Application Reference: EN010056

Our Reference: DIO 17608

30th September 2020

The East Anglia Three Offshore Wind Farm Order 2017 (as amended) Application for a Non-material Change 2020
Infrastructure Planning (Changes to, and Revocation of, Development Consent Orders) Regulations 2011 (as amended) (2011 Regulations) (Application)

Doc Reference	2.11
APFP Regulation	5(2)(o)
Date	October 2015
Author	East Anglia THREE Limited
Revision History	A

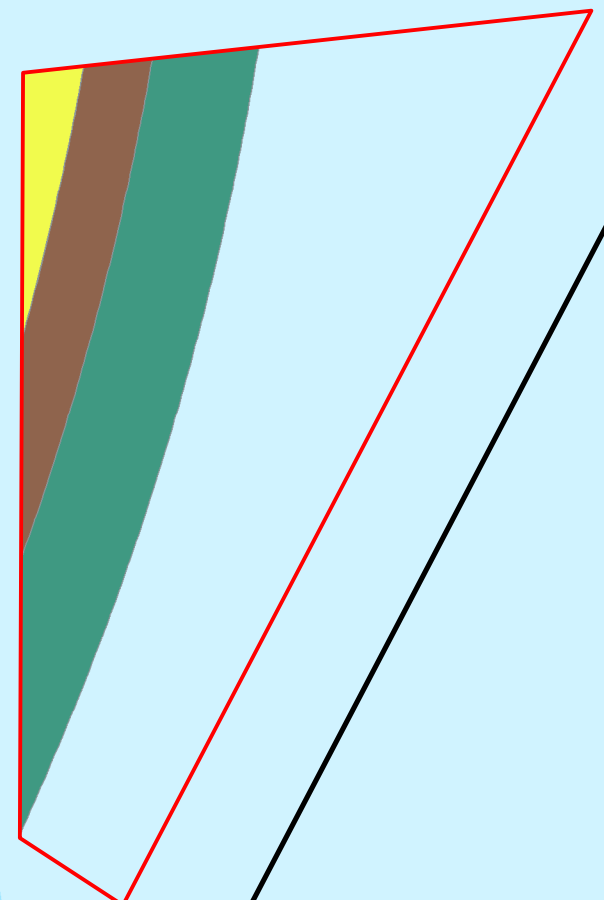
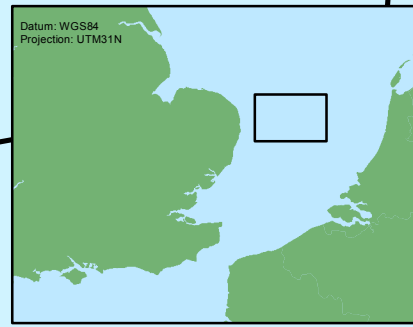
The proposed amendments would serve to redefine the maximum heights that wind turbines deployed in specific areas of the offshore development envelope (defined in a plan appended to the 2017 DCO) could be built up to without requiring a technical mitigation. As identified above, the applicant's modelling of the radar detectability of turbines that may feature in this scheme is not suitable for precisely defining the maximum heights turbines could be built up to within specific areas of the development envelope without causing unacceptable and unmanageable interference to the air defence radar. The MOD does not consider that such precise development limitations can be prescribed in this way whilst ensuring the effective operation of the air defence radar. Since the height parameters defined in the 2017 DCO were agreed, the MOD has completed radar trials and gained a greater understanding of the regular performance attributes of the type of air defence radar system in use at RRH Trimingham. As such, this use of siting and design parameters to address air defence radar safeguarding requirements is no longer suitable.

Therefore, the MOD cannot accept the amendment of Requirement 33 as currently proposed. Instead an alternative version of this Requirement, acceptable to the MOD, is attached at Annex A. This alternative version uses wording that the MOD considers suitable for the purpose of addressing air defence safeguarding requirements, based on current information and understanding, by identifying a need for the provision of a technical mitigation. The MOD respectfully submits this for the consideration of the Examining Authority.

1. No development of any wind turbine generator forming part of the authorised development shall commence unless and until an Air Defence Radar Mitigation Scheme (“the ADRM scheme”) has been submitted to and approved in writing by Secretary of State in conjunction with the Ministry of Defence (MOD).

For the purposes of this condition, the ADRM Scheme means a detailed scheme to mitigate the adverse impacts of the development on the air defence radar at Remote Radar Head (RRH) Trimingham and the air surveillance and control operations of the MOD. The scheme will set out the appropriate measures to be implemented to that end.

2. No wind turbine erected as part of this development shall be permitted to rotate its rotor blades about its horizontal axis, other than for the purpose of testing radar mitigation for this development for specific periods as defined in the approved ADRM scheme or otherwise arranged in accordance with provisions contained in the approved ADRM scheme, until:

- a) those mitigation measures required to be implemented prior to any wind turbine being permitted to rotate its rotor blades about its horizontal axis as set out in the approved ADRM scheme have been implemented; and
- b) any performance criteria specified in the approved ADRM scheme and which the approved ADRM scheme requires to have been satisfied prior to any wind turbine being permitted to rotate its rotor blades about its horizontal axis have been satisfied and the Secretary of State, in conjunction with the Ministry of Defence, has confirmed this in writing.
